# Charlotte Department of Transportation

## Memorandum

**Subject:** Rezoning Petition 08-139: Located on the north side of Ballantyne Commons Parkway between Rea Road and Williams Pond Lane

SITE PLAN

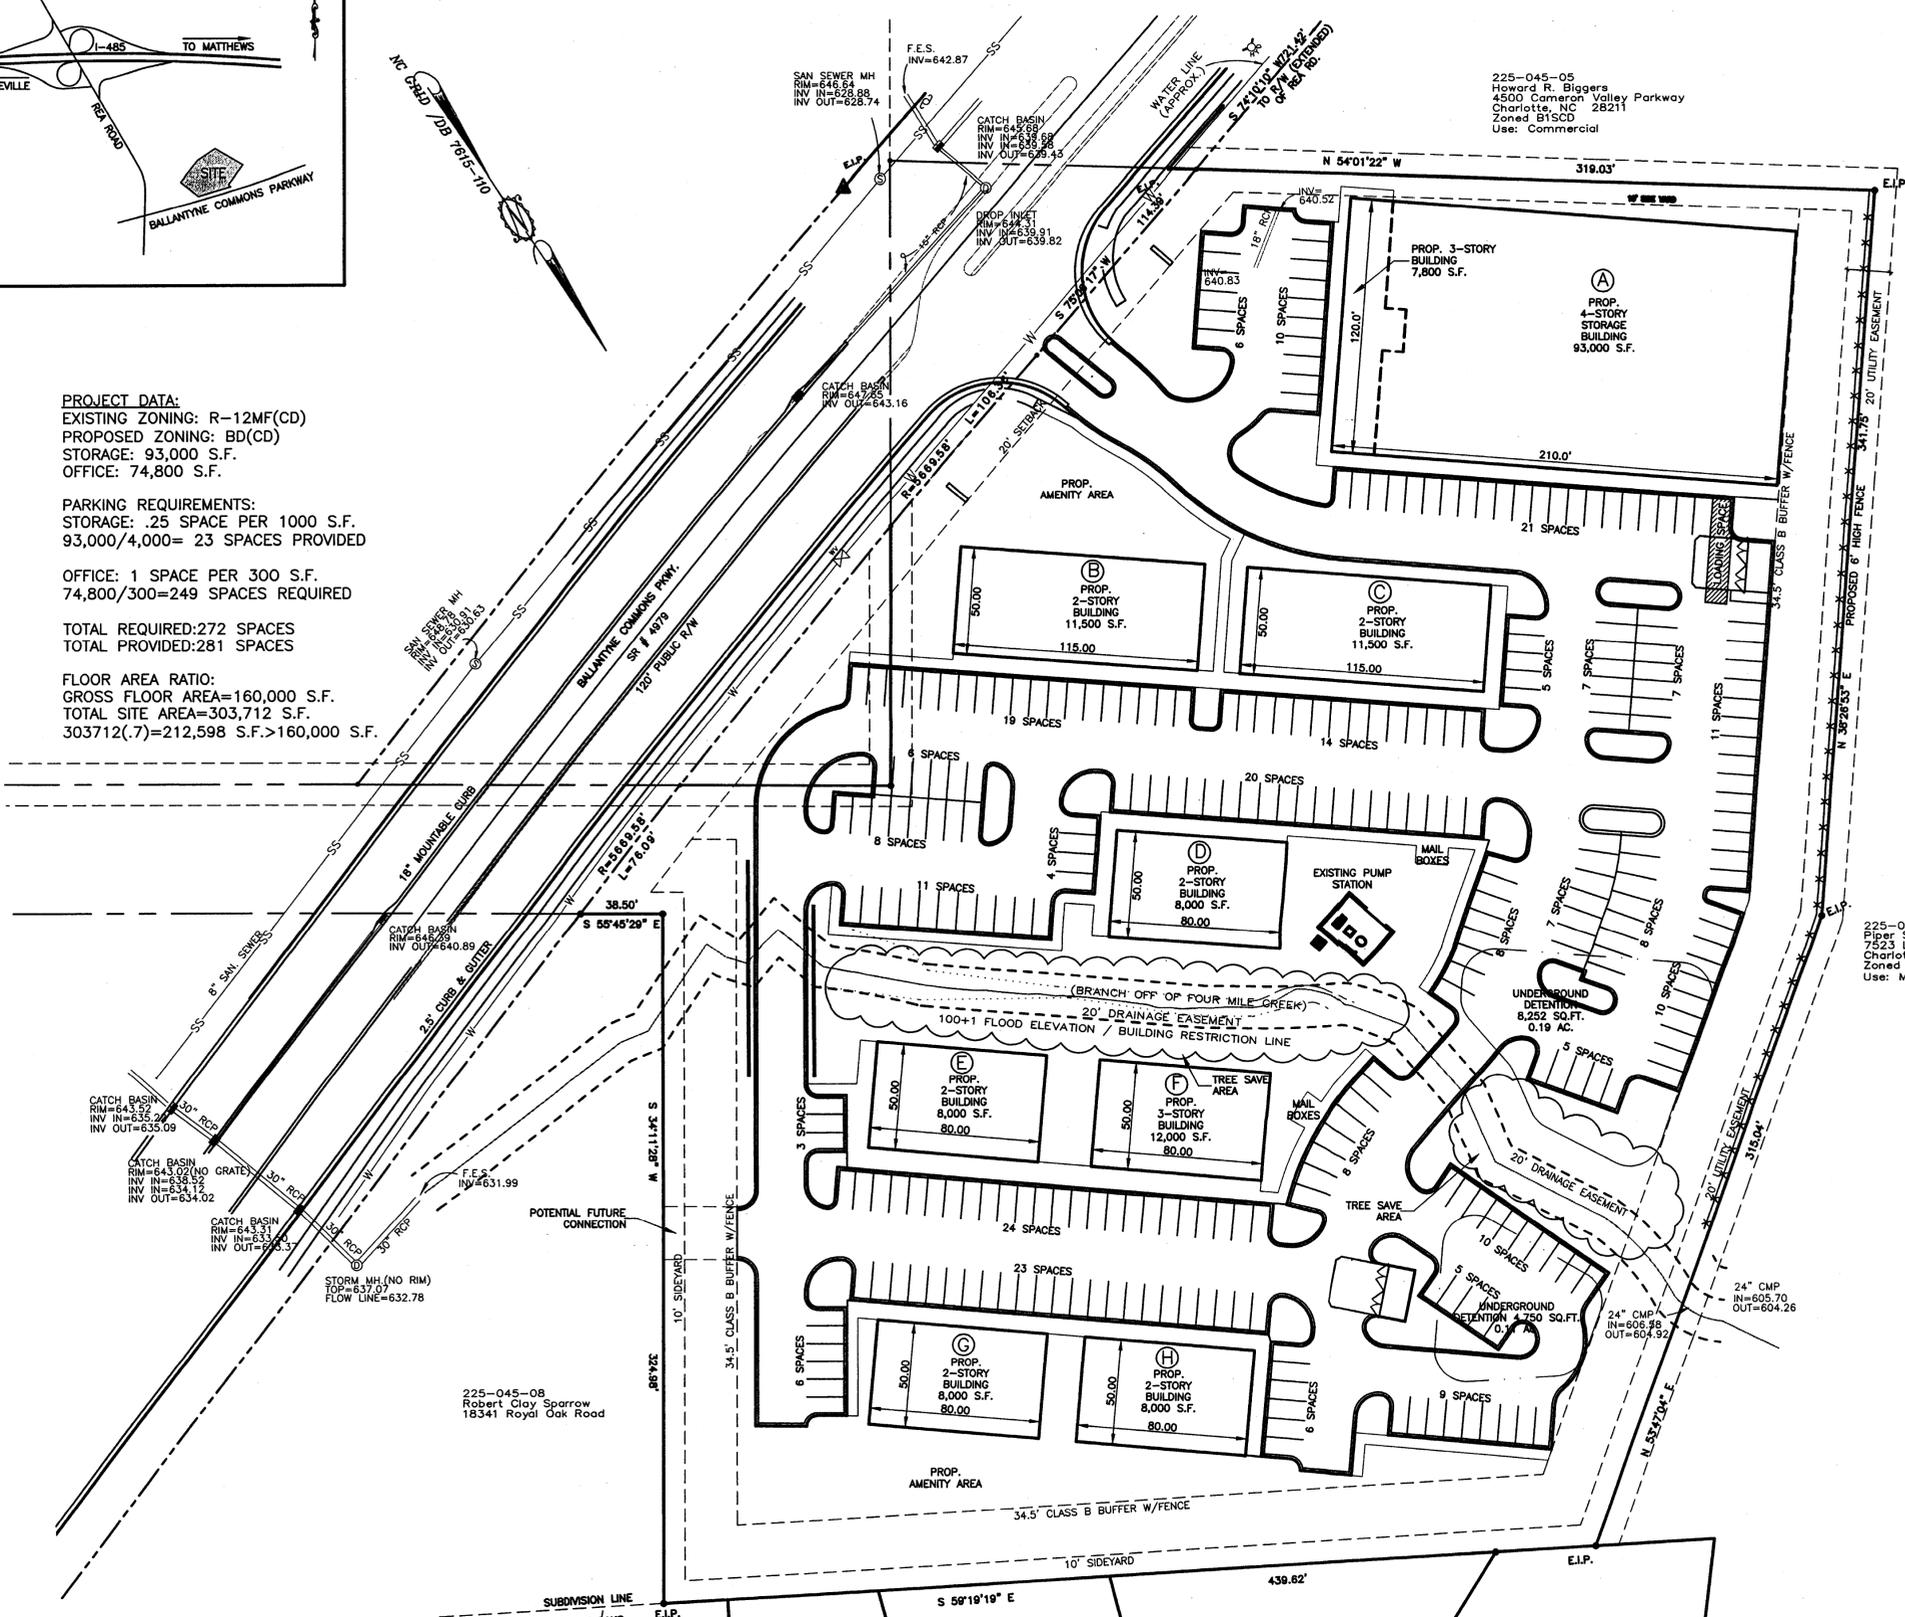
1. Should the developer consider a private street(s) in lieu of a driveway/aisle, we request that it be designed as a Local Office/Commercial Street – Narrow (Urban Street Design Guidelines-USDG). Such typical cross-section has a 25-foot back-of-curb width with a 20-foot wide two-way mixed vehicle zone between curb-and-gutter, as well as 8-foot planting strips and 5-foot sidewalks.
2. This property needs to have cross access/easement with the adjacent property to the east to provide inter-connectivity and access between uses that will not require unnecessary use of

Ballantyne Commons Parkway. To facilitate future cross access, the stub driveway shown on the site plan to Parcel 225-045-08 needs to be shown all the way to the property line.

3. Drive aisles through parking lots should be designed to avoid minor offsets. Near Buildings F and H, the configuration of the drive aisles to the northern-most parking areas needs to be consolidated and better aligned for through movements.

Adequate sight triangles must be reserved at the existing/proposed street entrance(s). Two 35' x 35' and two 10' x 70' sight triangles are required for the entrance(s) to meet requirements. All proposed trees, berms, walls, fences, and/or identification signs must not interfere with sight distance at the entrance(s). Such items should be identified on the site plan.

- Meet applicable standards in the Charlotte Land Development Standards Manual (latest revision).
- Dimension width of the existing and proposed driveways.
- Indicate typical parking module dimensions.
- Include a parking summary with figures for the numbers of parking spaces required and provided.
